PROPOSED PORT TERMINAL AT  
FORMER TILBURY POWER STATION

# TILBURY2

ES APPENDIX 9.A: CONSULTATION EXERCISE FOR LVIA

## TILBURY 2- NSIP LANDSCAPE AND VISUAL ASSESSMENT CONSULTATION EXERCISE

VIEWPOINT 44 - EXISTING VIEW

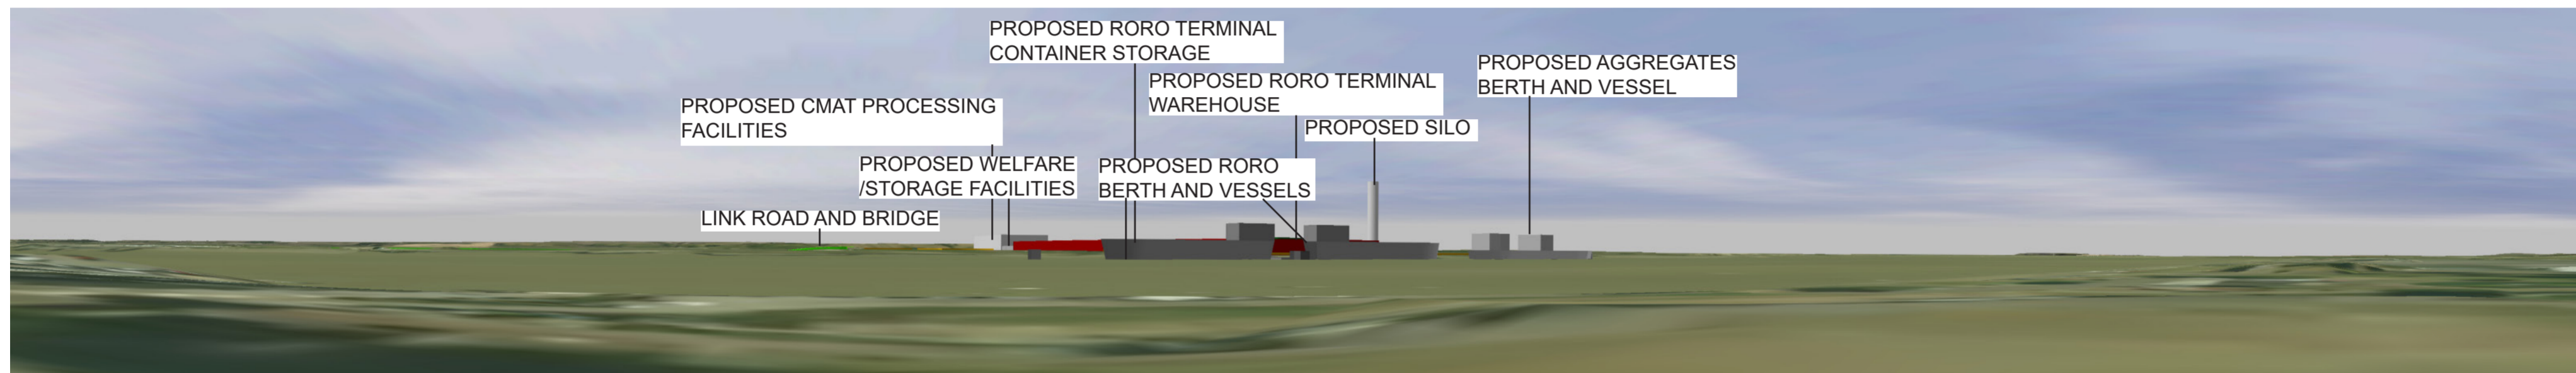
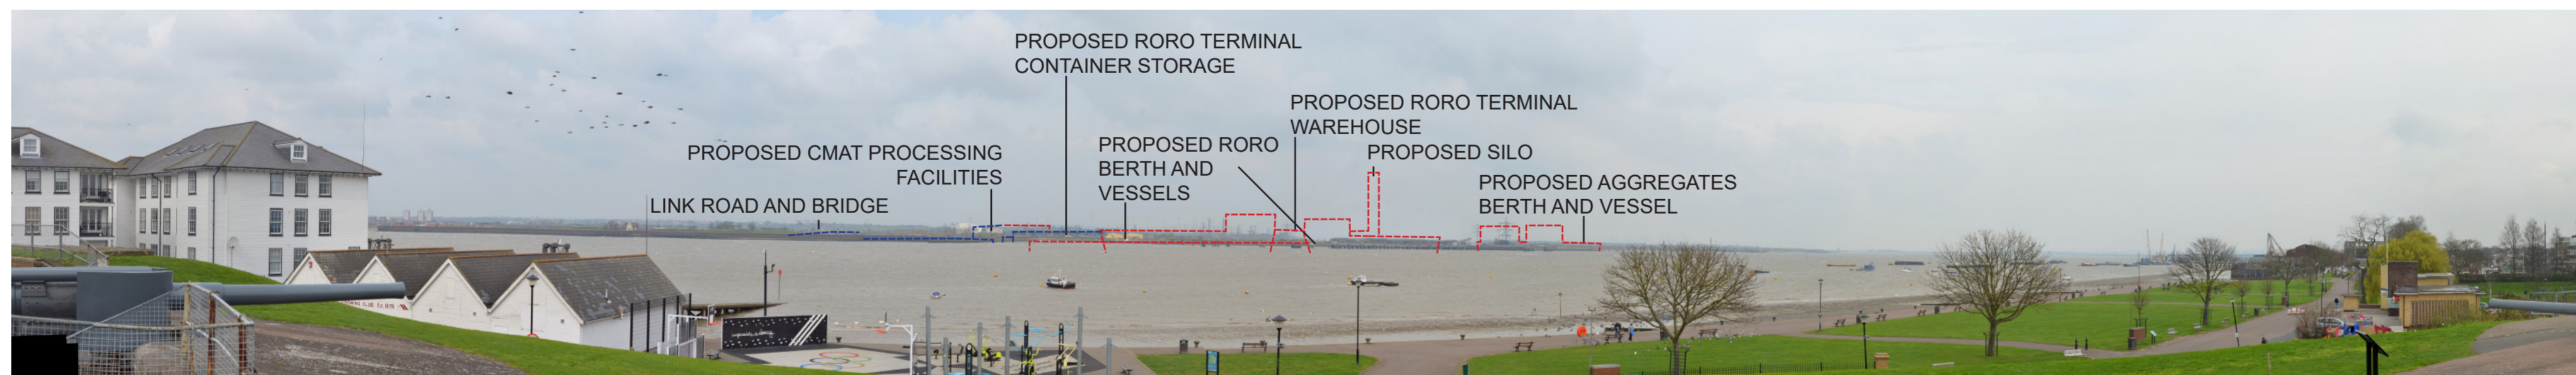
We are told how big these ships will be and the maximum that would be berthed there at any one time (i.e. 2 x Ro-Ro and 1 x aggregates ship) but none of the computer generated images in appendix 9F include them. We would suggest that the final ES include photomontages to illustrate the visual impact of the proposal from the southern shore with and without ships in place. The 'with ship' scenario should show the maximum number that can be berthed.

**Visualisations:** The predicted visual effects visualisations show only one ship moored whereas the ro-ro will accommodate two at any one time, in which case worst case scenario should be shown ( viewpoints 44, viewpoint 59).

A full set of draft wireline imaging representing potential effects from all identified representative viewpoint locations was supplied to HE on
